22 Hawthorne St.

Bld. Addition

RE: Application for Building Addition: 1 to 2 Unit, at 22 Hawthorne Street (App.# 2006-0075)

RE: Application for minor site plan/2-unit at #22 Hawthorne Street (App.# 2006-0075)

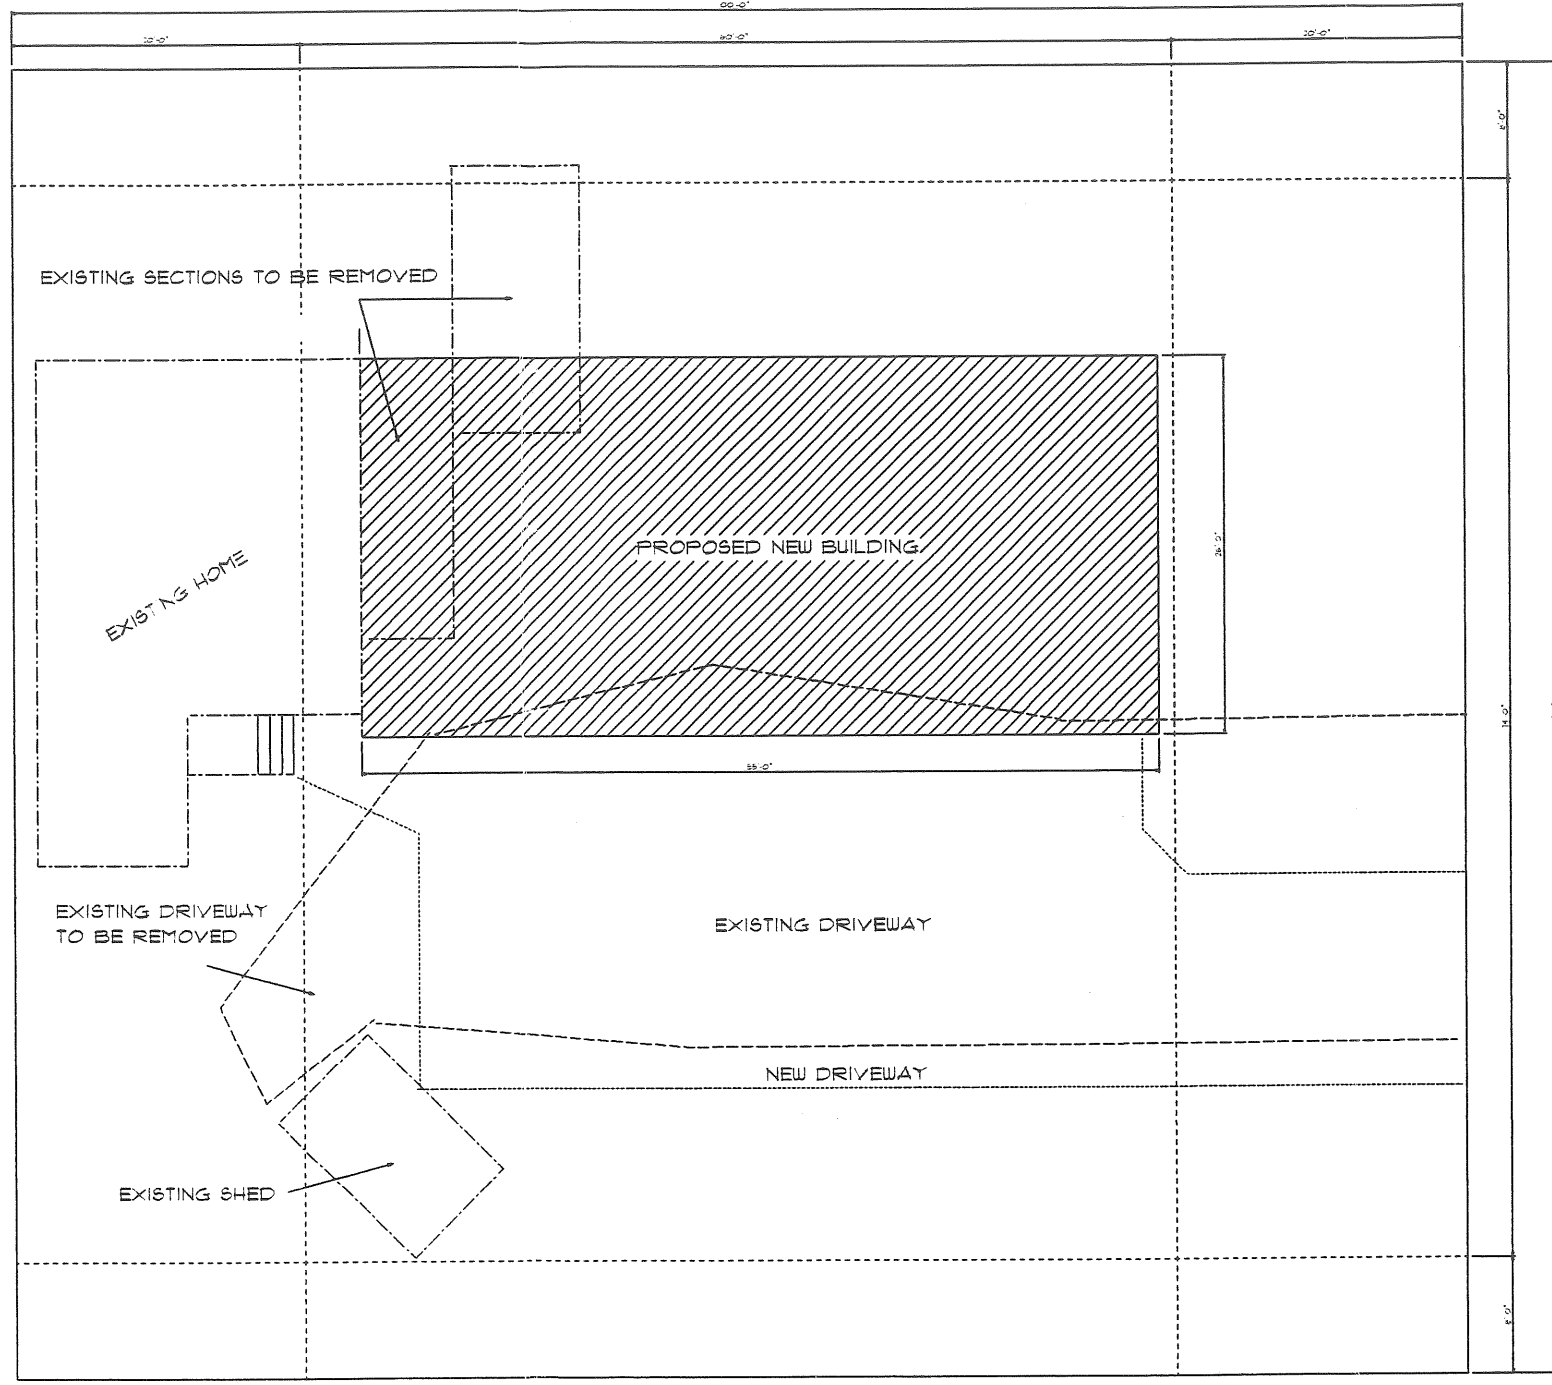
1. Please provide a survey of the property.
2. The site plan does not show any topography. Due to the increase in impervious surface (building and pavement), some method of managing the stormwater flows is required. Please show how drainage ^{does} not negatively impact the neighboring properties.

3. Please indicate the Finish Floor Elevation of the building addition (on the site plan).
4. Indicate whether any exterior lighting is proposed with this application.

5. For multi-family development, a minimum of 2 street trees and foundation plantings are required. Street trees are to be installed along a property's street frontage. Please add to your site plan.
